Application no: H09-0731-09

Description: First floor extension

Location: 13 Northons Lane
Holbeach
Spalding
PE12 7PZ

Amendment: Change in roof design and removal of dormer
window

TWO STOREY EXTENSION 13 NORTONS LANE, HOLBEACH			
Client MR AND MRS HUBBARD			
Drawing Title PROPOSED ELEVATIONS			
Drawn DC	Scale 1/100	Sheet A3	Date 03.09.09
DRAWING STATUS			
Issued Only ☒	Planning ☒	Building Regs ☐	Approved ☐
Job No. 09-004	Draw No. 2P01	Revision 00

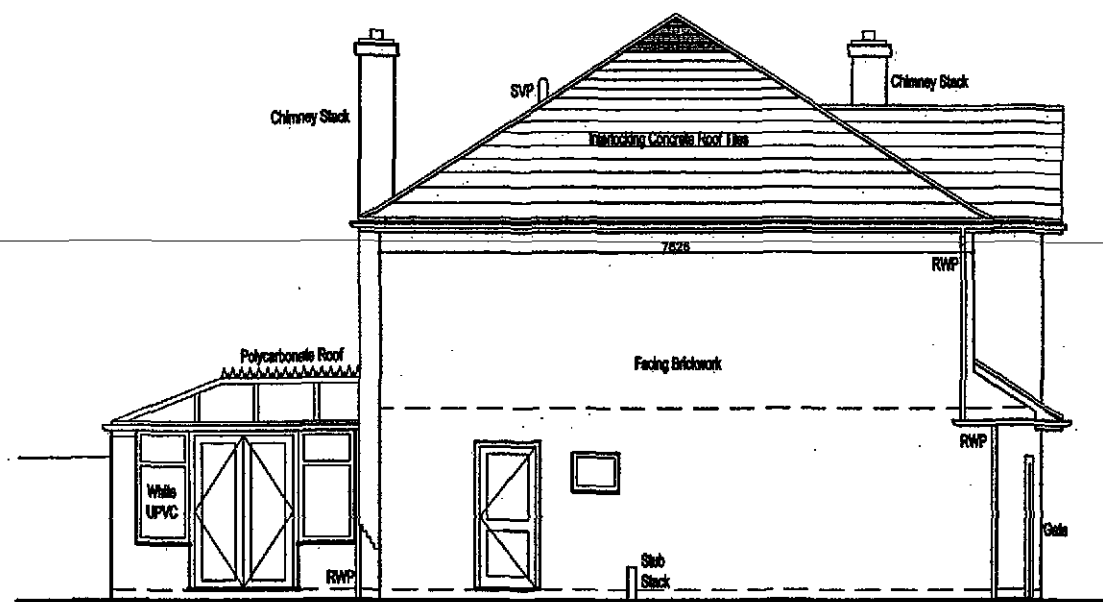
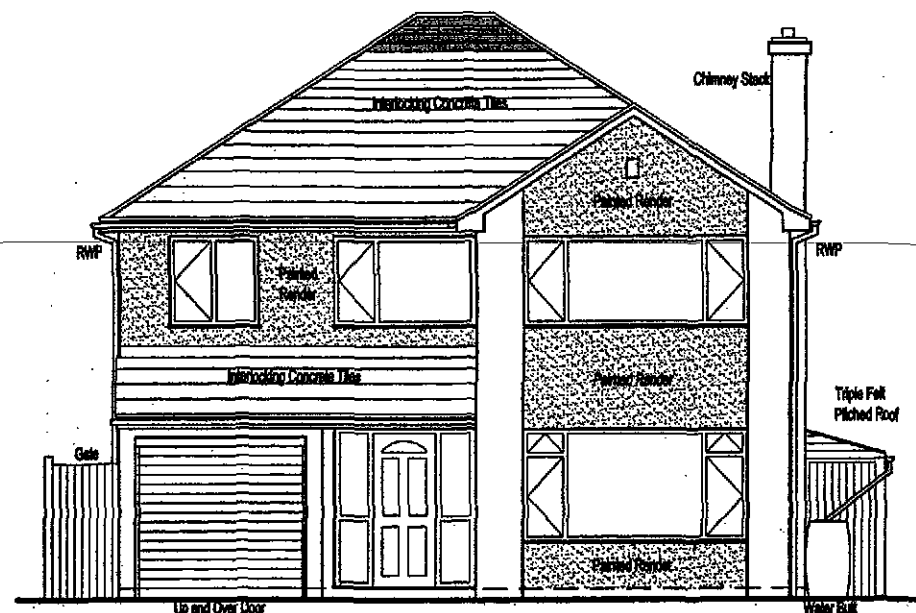
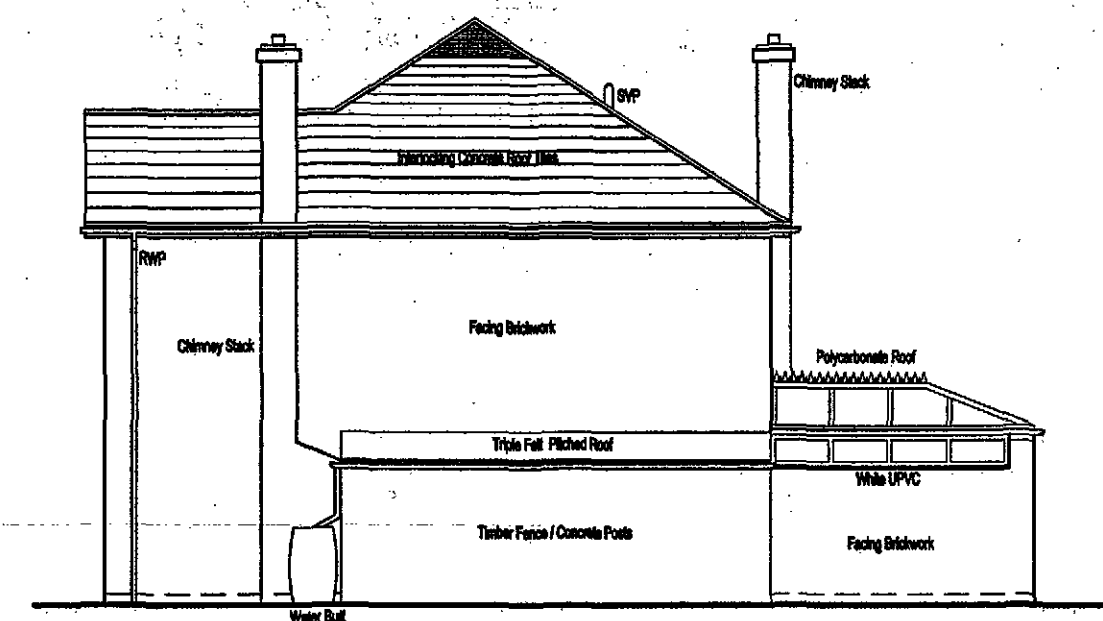
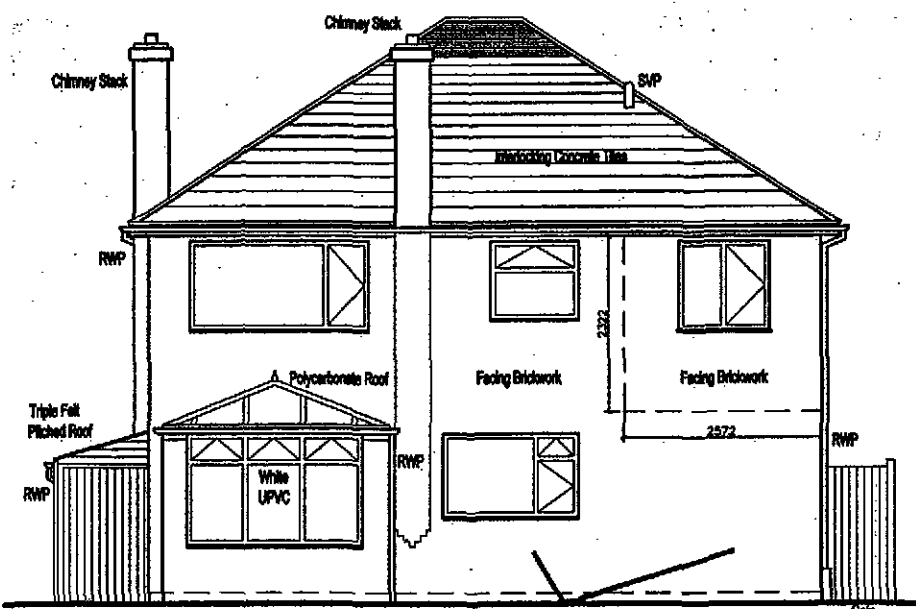
FULL DESCRIPTION OF DEVELOPMENT OF CURRENT APPLICATION THAT THIS AMENDMENT RELATES TO	FIRST FLOOR EXTENSION	
State details of amendments proposed. (Give a full detailed list of the changes, and also mark these clearly on the accompanying plans. Only the changes listed here will be considered)	CHANGE IN ROOF DESIGN AND REMOVAL REMOVAL OF DOGGER WINDOW	
State drawing numbers of the current submission		
Has this amendment been requested by the Council? (If so, state Officer dealing with the application)	YES/NO	
Describe any part of the original development which is excluded by virtue of the amendment, and state any alteration to plot numbers		
Has a similar amendment been submitted under Building Regulations? (If so, state Building Control Surveyor dealing with application)	YES/NO
